Your ref:  
Our ref: 21/00223/LDP  
Please ask for: Mrs Rebecca Bush  
Direct dial: 01553 616825  
Direct fax: 01553 616652  
E-mail: borough.planning@west-norfolk.gov.uk

Details: **Certificate of Lawfulness: Proposed summer house/sauna at 6 Glebe Estate  
Tilney All Saints King's Lynn Norfolk PE34 4SN**

Front (Elevation 1)

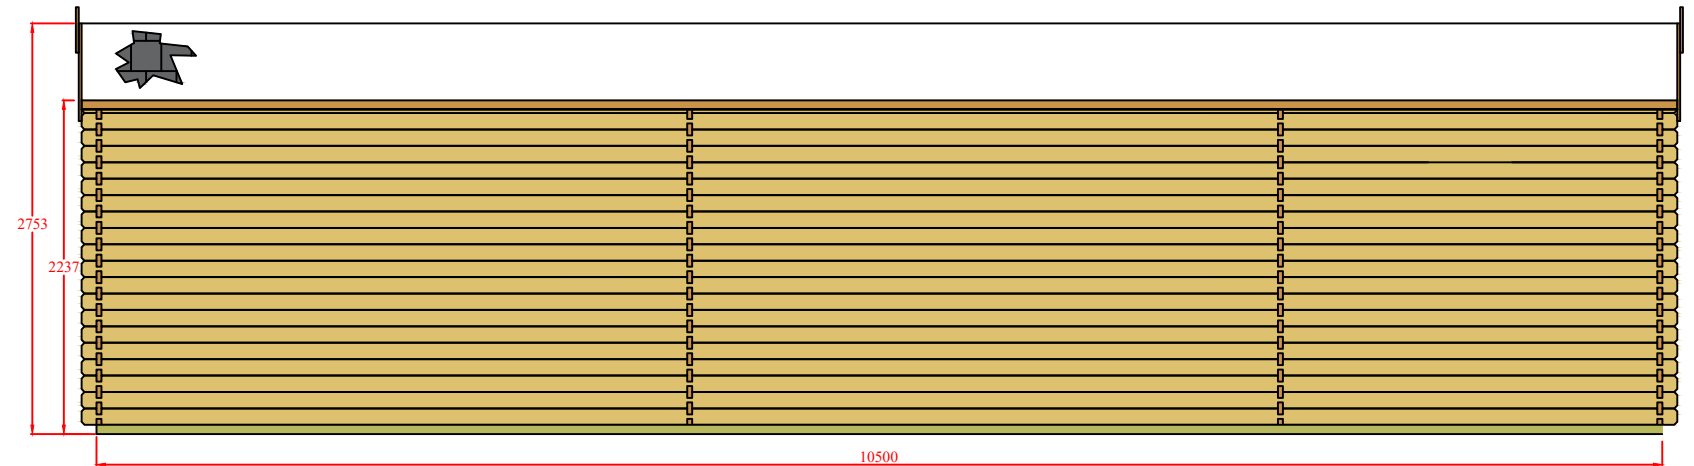
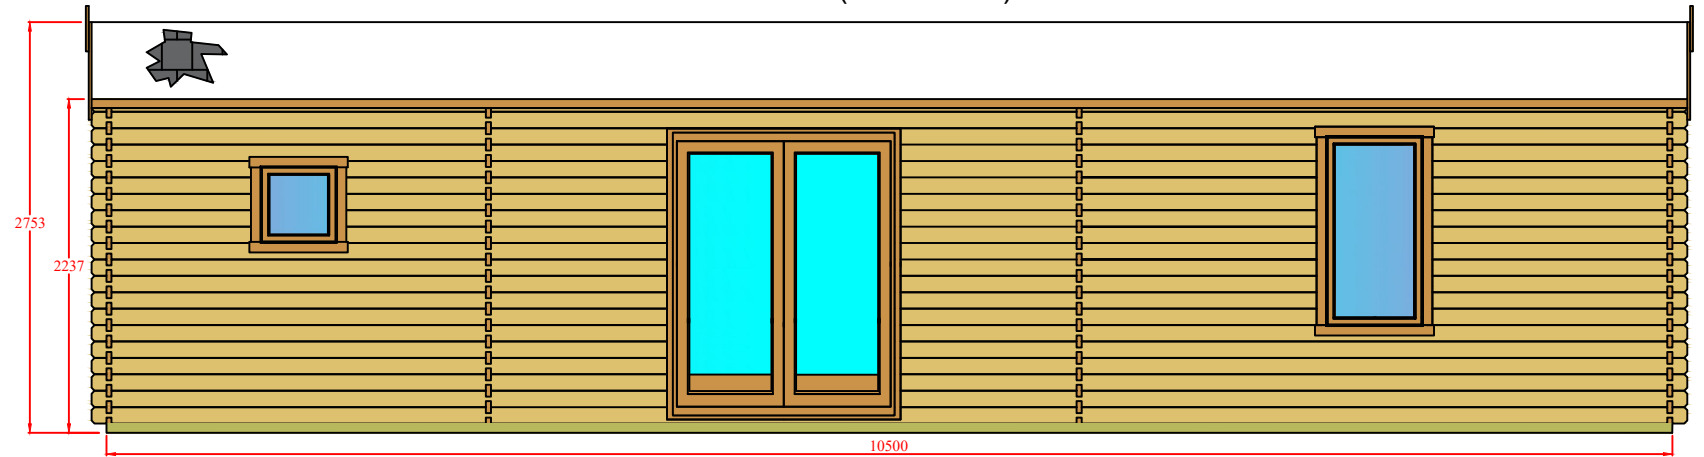
1. Is the sauna actually in your back garden if so you have paid too much money and we will need to refund you £128. Please can you confirm in writing.
2. Unfortunately we do require a location plan to a scale of 1:1250, please submit at your earliest convenience.
3. Please can you send your floor plan as a PDF so the scaling is correct. Please can you also inform us of the height.
